SNAPPER MINE

Northern Extension Modification

Submissions Report

JANUARY 2020
Project No. CMA-19-08
Document No. 01007985

Figure 3 | Proposed Final Landform

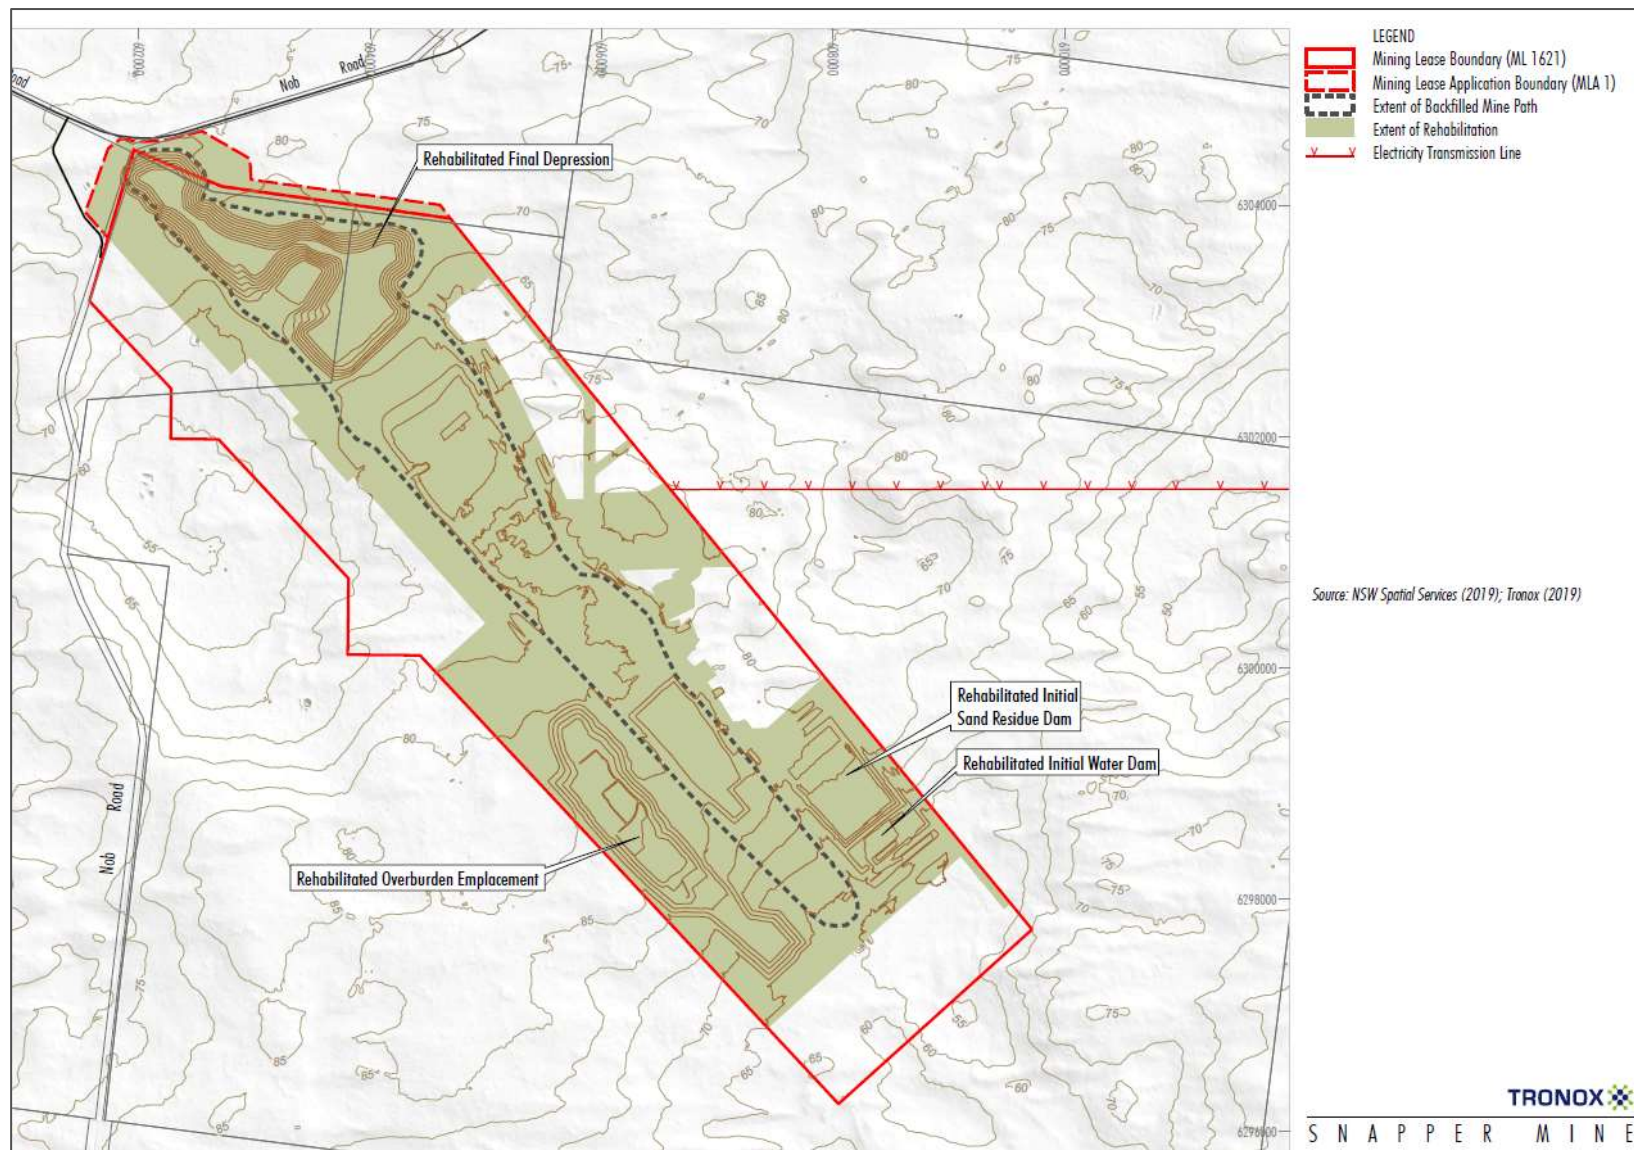
The DPIE requested that Figure 6 of the Modification Report be updated to include a scale and the increments of the surface contour lines shown on the inset.

The Manilla property leaseholders provided a comment regarding the rehabilitation of the Modification area (including a portion of the modified final depression) within the Manilla property, specifically in relation to the safety and suitability of the rehabilitated final landform for the approved final land use of light intensity grazing.

Figure 5 of the Modification Report has also been updated to show the increments of the contours lines and is provided as Figure 3.

As described in Section 3.1, as a result of ongoing consultation with the Manilla property leaseholders, Tronox would backfill the portion of the modified final depression inside the Manilla property so that it is level with the surrounding natural ground surface (Figure 3).

Figure 4 | Proposed Final Depression

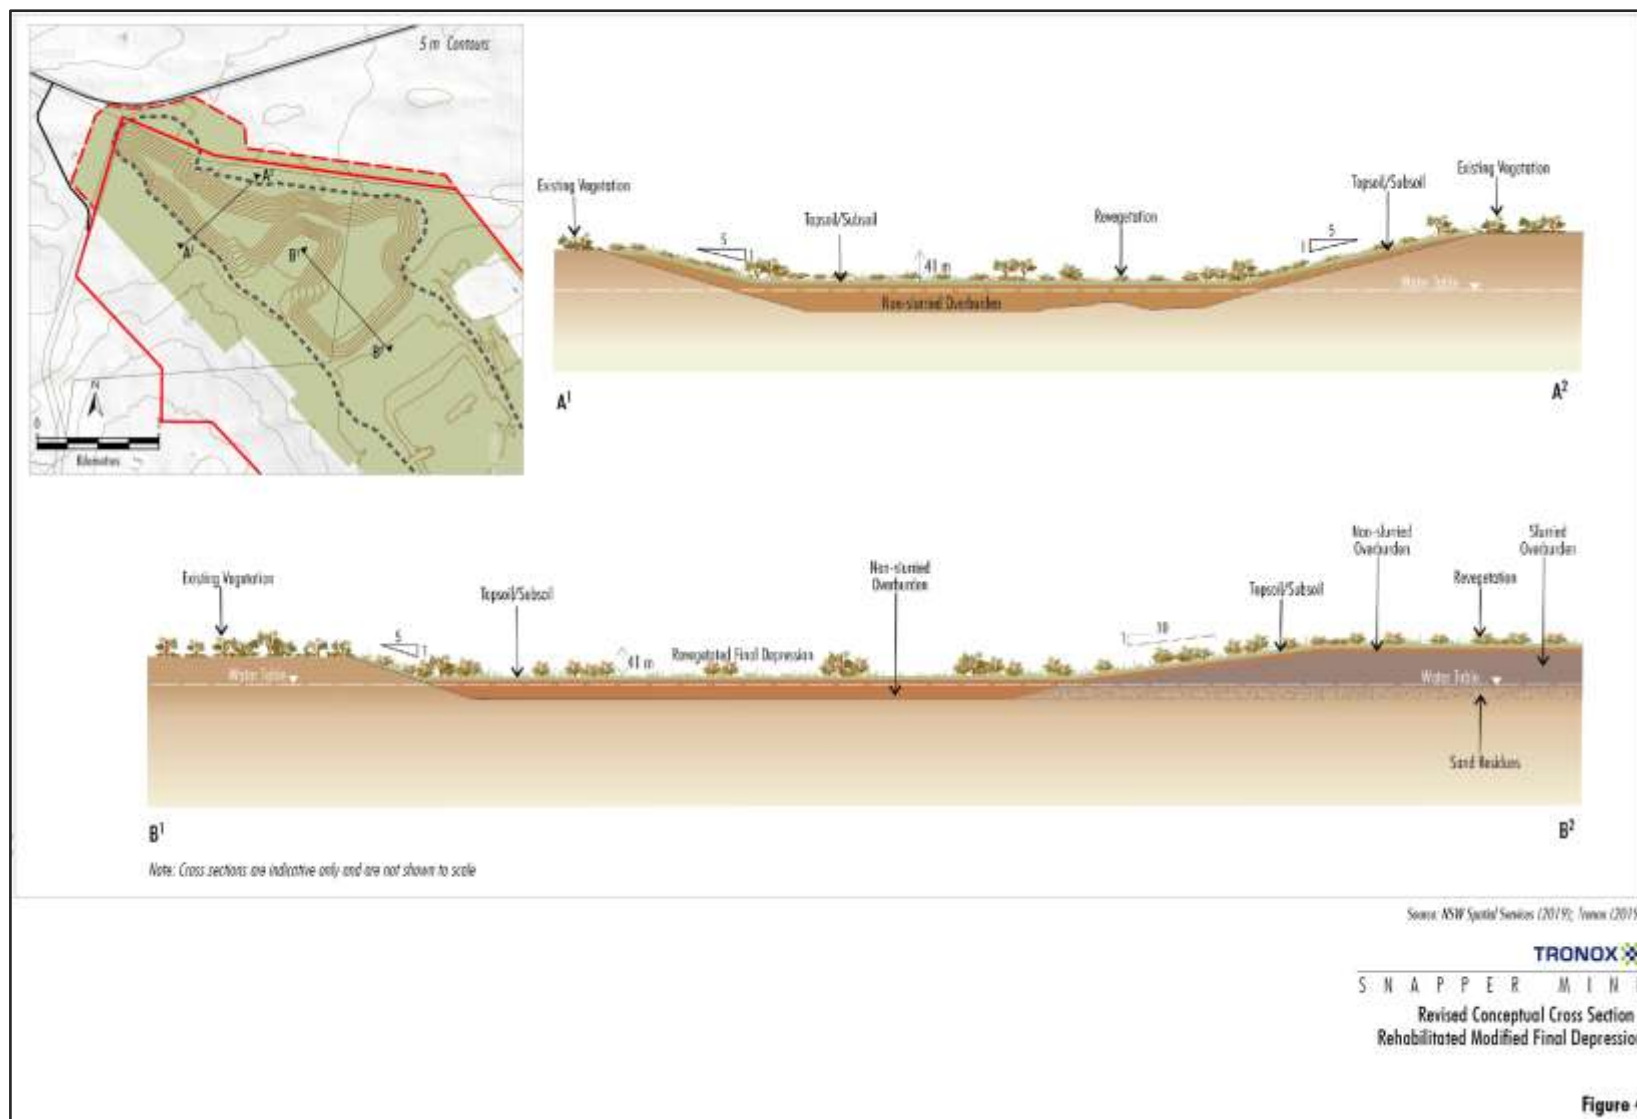
The DPIE requested clarification regarding the grade of the batter slopes for the modified final depression.

The slopes of the approved final depressions are 1:4. The Modification would reduce the grade of the batter slopes to between 1:5 and 1:10 (Section 2.5.2 of the Modification Report) (Figure 4).

Figure 6 of the Modification Report has been updated and is provided as Figure 4. Figure 4 shows the indicative final depression depth, batter slopes and the increments of the surface contour lines. Figure 4 also notes that the conceptual cross sections of the modified final depression are indicative only, and are not to scale.
